Our reference: ECM Ref: 9772045
Contact: Kathryn Saunders
Telephone: (02) 4732 8567

17 November 2021

Department of Planning, Industry and Environment
Attn: Rebecka Groth
Email: rebecka.groth@planning.nsw.gov.au

**Request for Advice - EIS - Access Logistics Park SSD-17647189 at No. 884
– 928 Mamre Road Kemps Creek**

Drawing Title:
Landscape Detail Plan 1
DWG No:

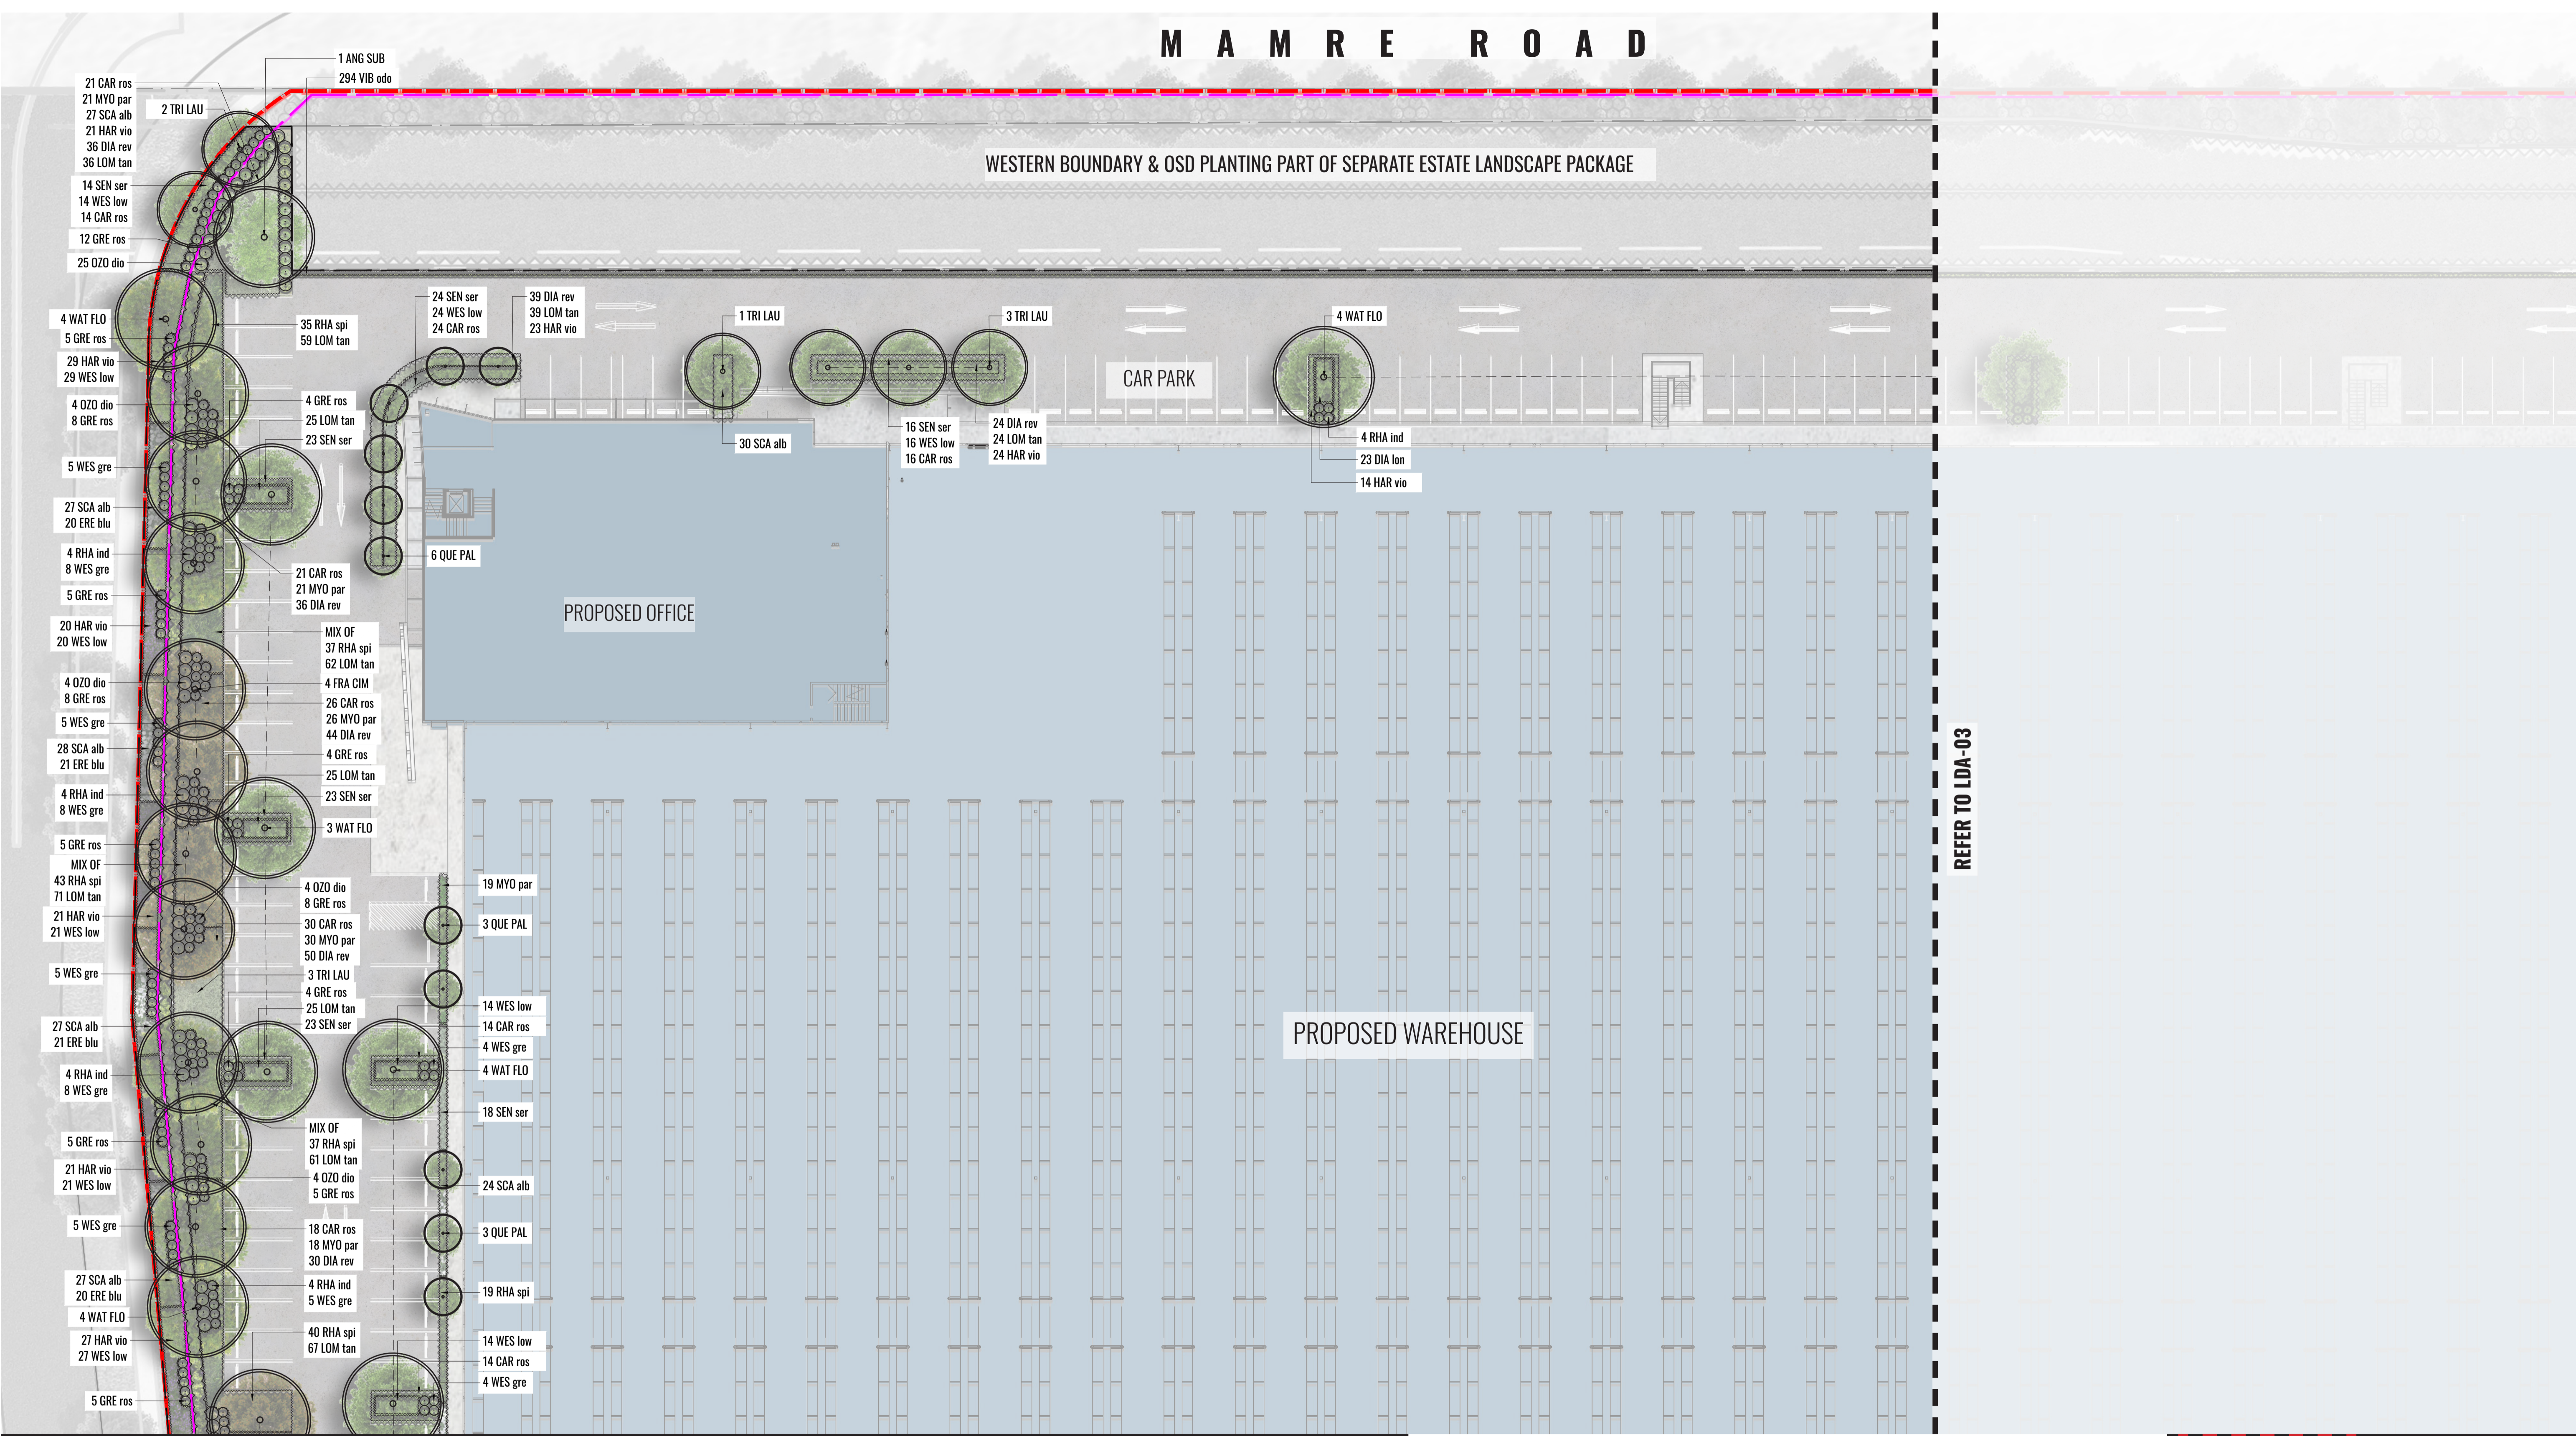
Landscape plans do not correlate with civil and architectural plan sets.

The proposed development must comply with the landscape setback requirements of the soon to be made Draft DCP. It is unclear if the required 10m landscaped setback to Mamre Road is provided post widening of Mamre Road.

The current concept plans indicate an inadequate setback to Mamre Road and it is unclear what areas will remain in private ownership after the planned widening of Mamre Road occurs. This must be made clear and landscaping assessment undertaken requiring compliance with the DCP.

Drawing Title:
Landscape Section AA & BB
 DWG No:
LDA-07

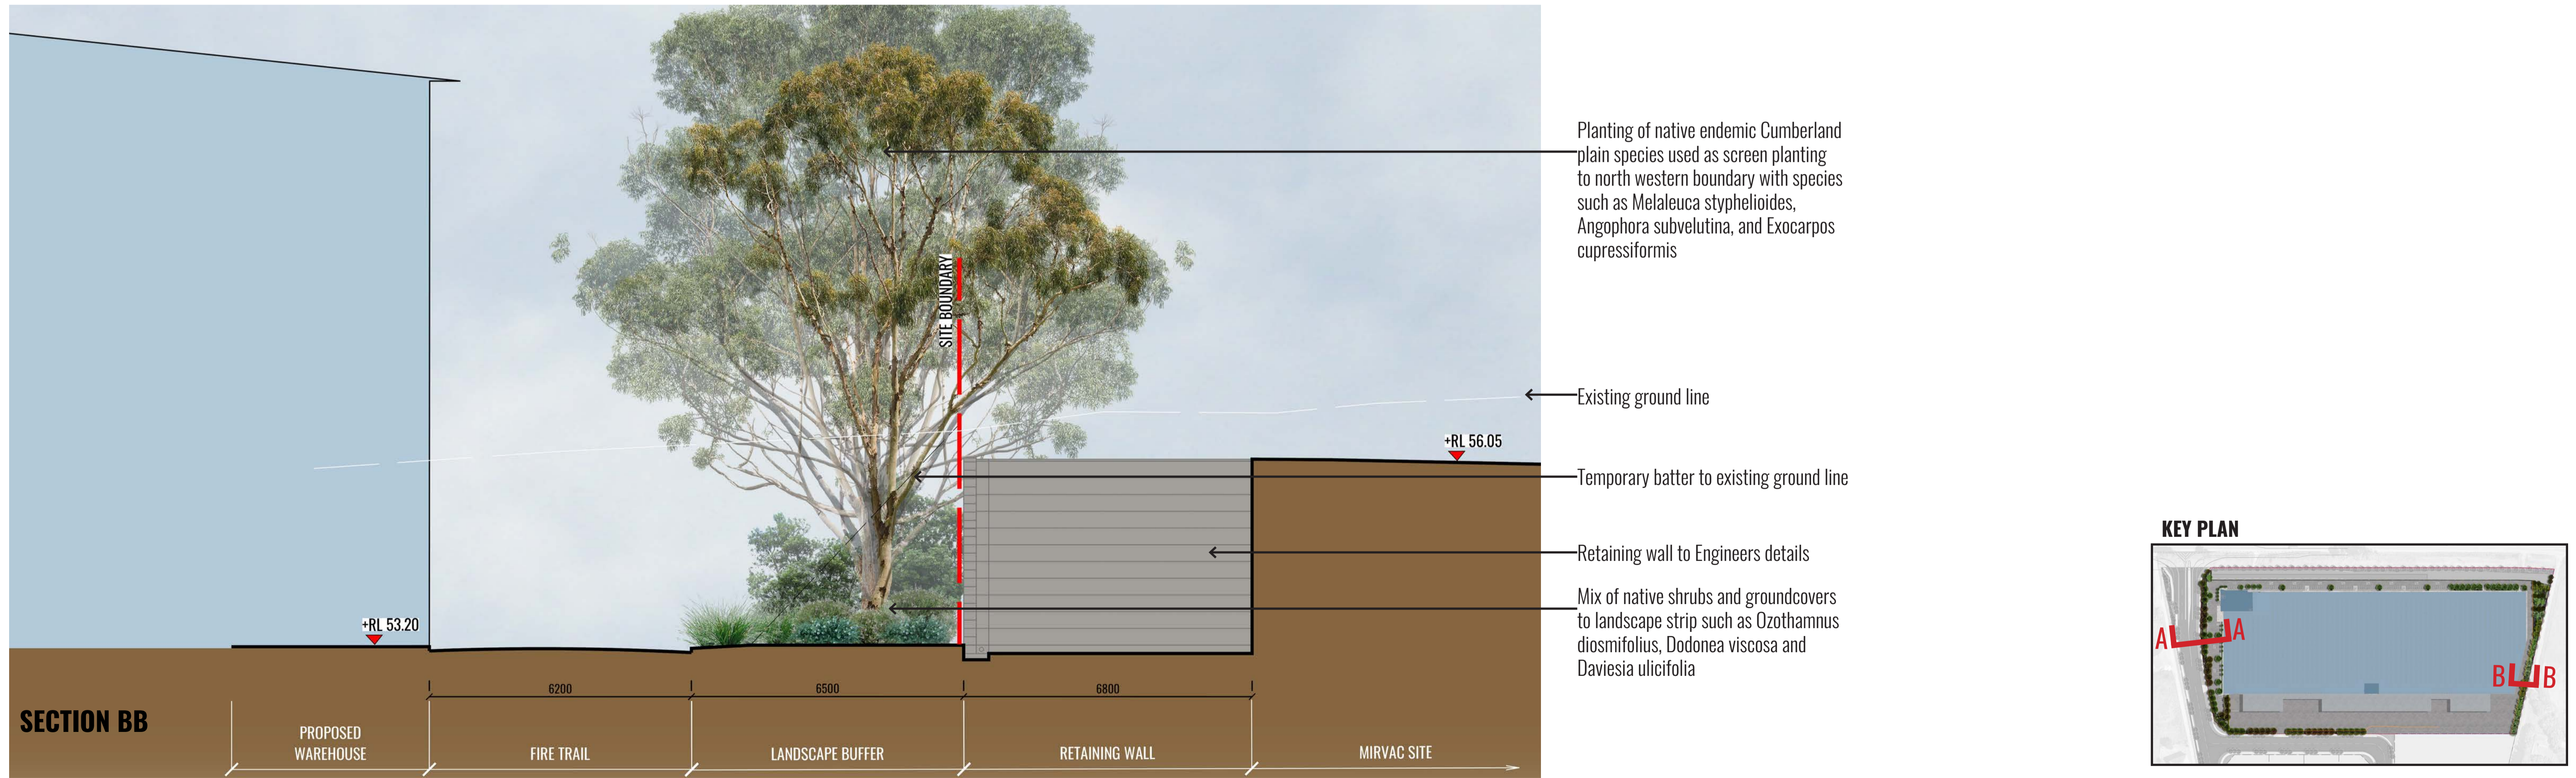
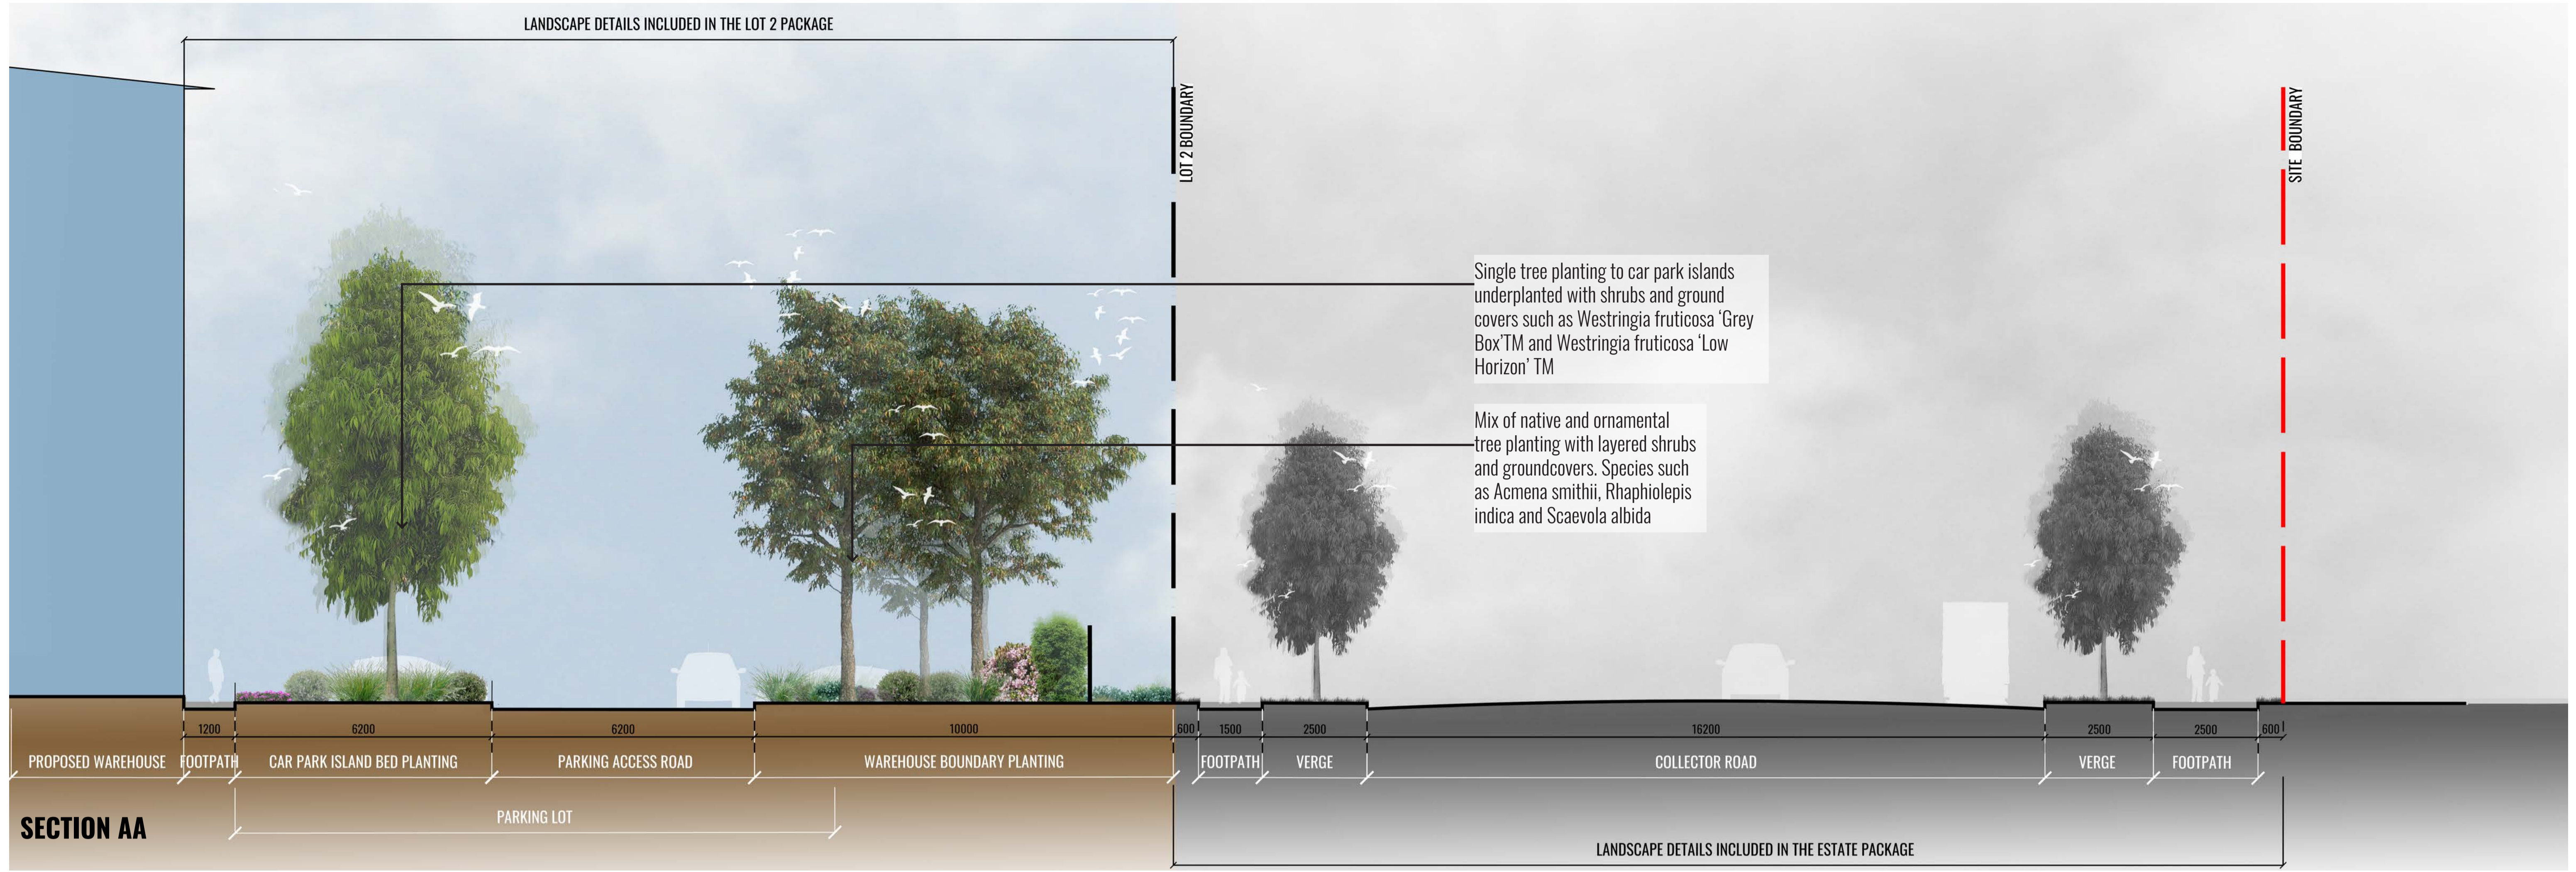
DPIE is strongly encouraged to require that the applicant suitably resolve the traffic, stormwater, water quality, levels and landscape issues raised. It is recommended that the applicant clearly indicate the ultimate of final Mamre Road (widened) alignment on all affected plans and sections (including on Section 1 - refer **Image 3** below). Documents are to detail the interim and ultimate/final roadway designs.

Sections indicate that Estate roads are proposed in deep areas of cut with high retaining walls hard up against the roadway boundary (example refer **Image 4** above). In relation to the levels proposed at image 4, it is not understood why Lot 16 is filled when natural ground level is consistent with the roadway.

The Draft DCP includes that level transitions are to be managed between lots and not interface the public domain. In accordance with section 4.4.1 of the Draft DCP, finished ground levels adjacent to the public domain or public road dedication, be no greater than 1.0m above the finished road level (or public domain level).

The Draft DCP includes that where a level difference must exceed 1m the landscaping and retaining walls are to be stepped back within the private lot and also required that walls up to 3m in height are to be setback 2m into the property boundary.

It is raised for the Department's consideration that all high retaining walls will require fencing for safety reasons, which has not been indicated on plans.
